**ADC Planning Consultation
Response from the Conservation Officer**

Application Number	K/29/15/HH
Address	The Tower Seaview Avenue Kingston BN16 1RZ
Description	Two storey extension to East, first floor extension to West & new pitched roof on existing garage (resubmission following K/20/15/HH).
Case Officer	Mr. David Easton

Drawing Name
Proposed Ground & First Floor Plans

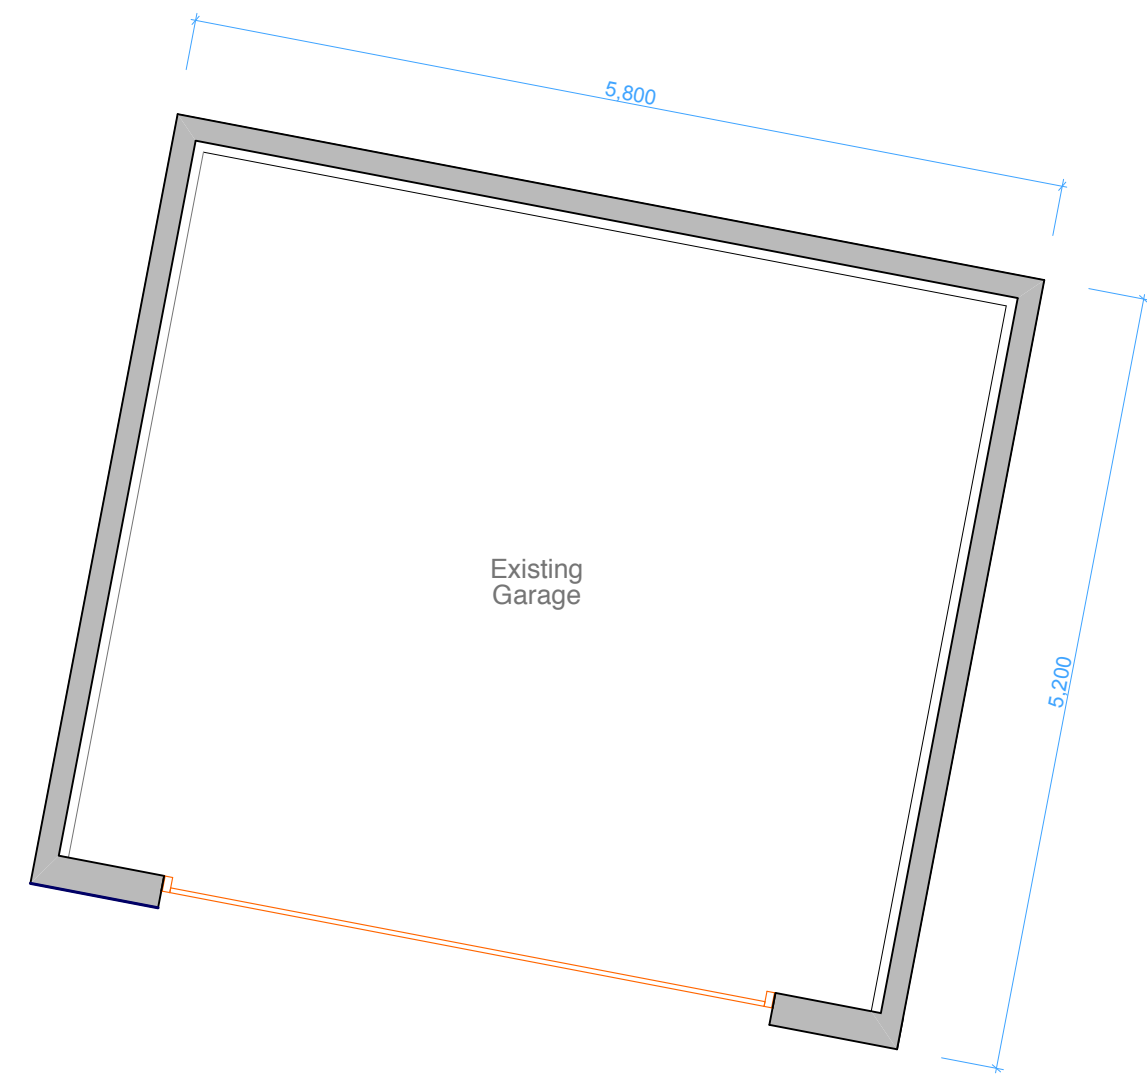
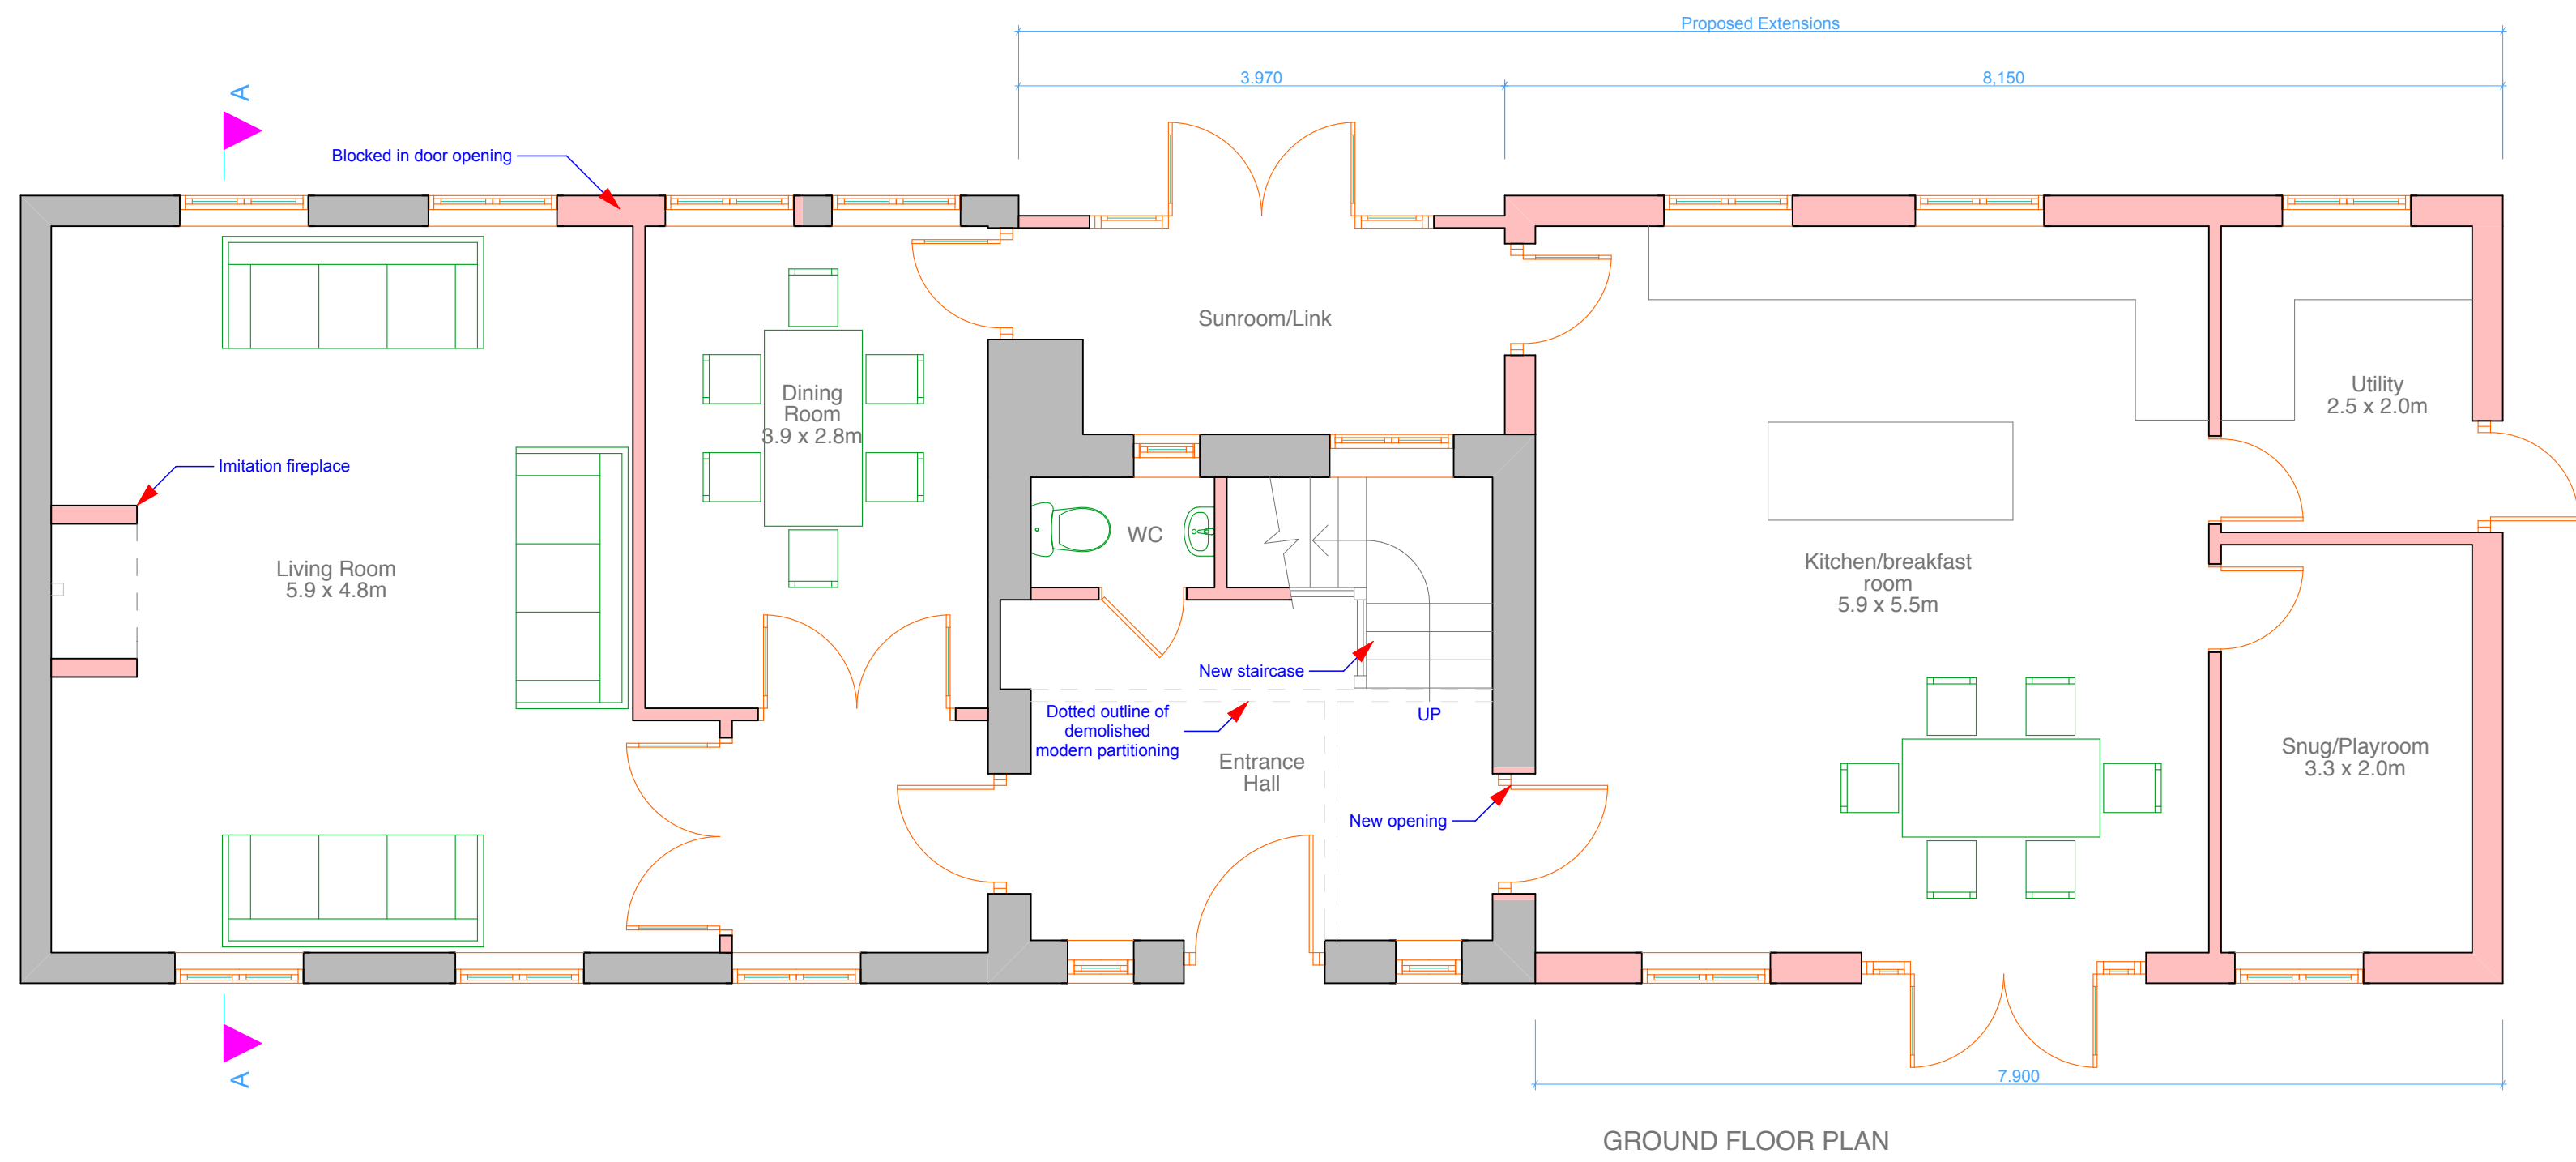
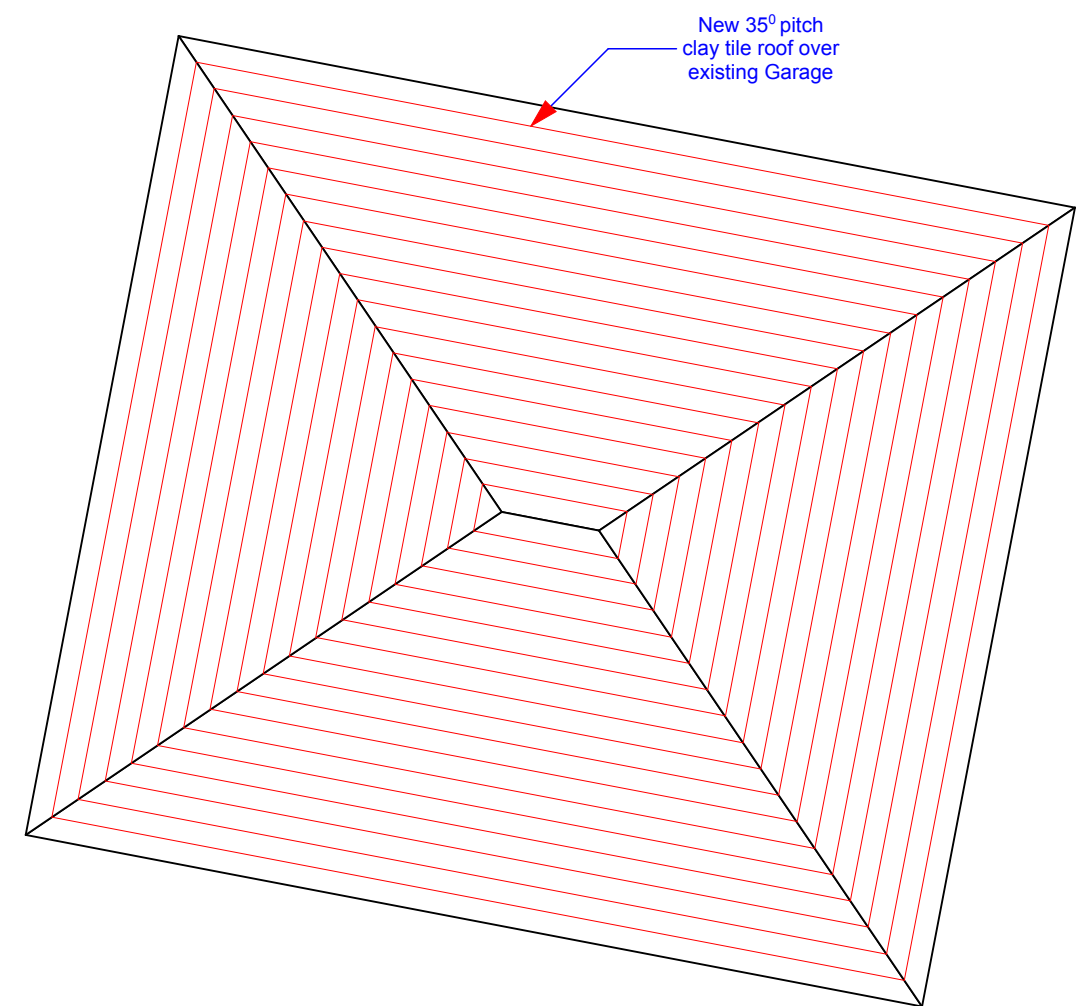
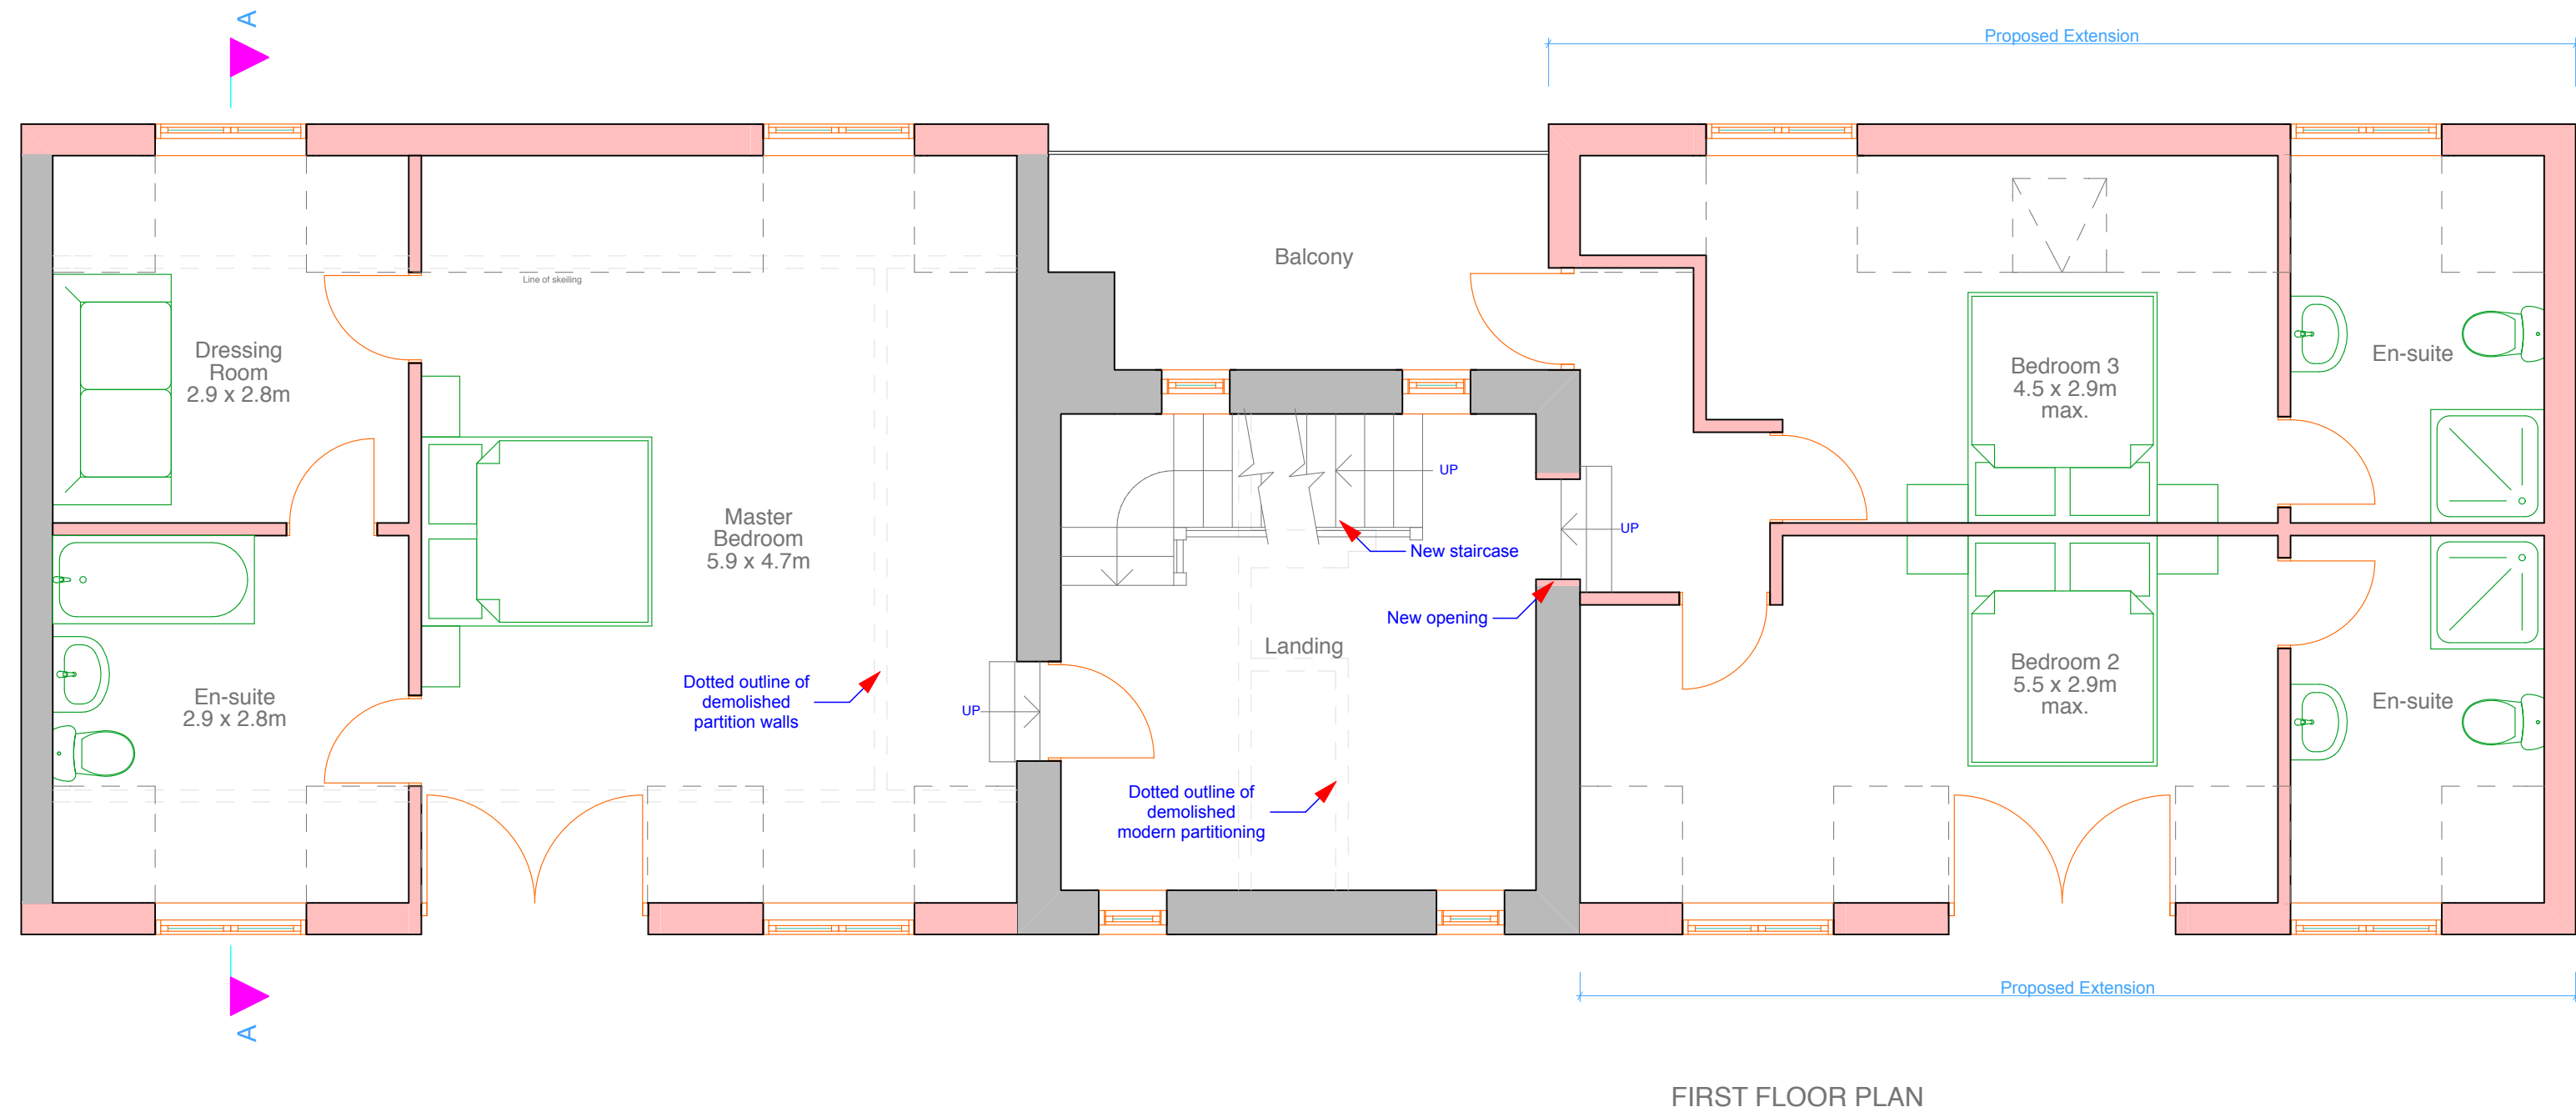
It is considered that the concept of an extension is more favorable now that it has been reduced in size, and separated from the garage. This enables the tower to retain a dominant position.

The revised garage is now considered to be much more acceptable.
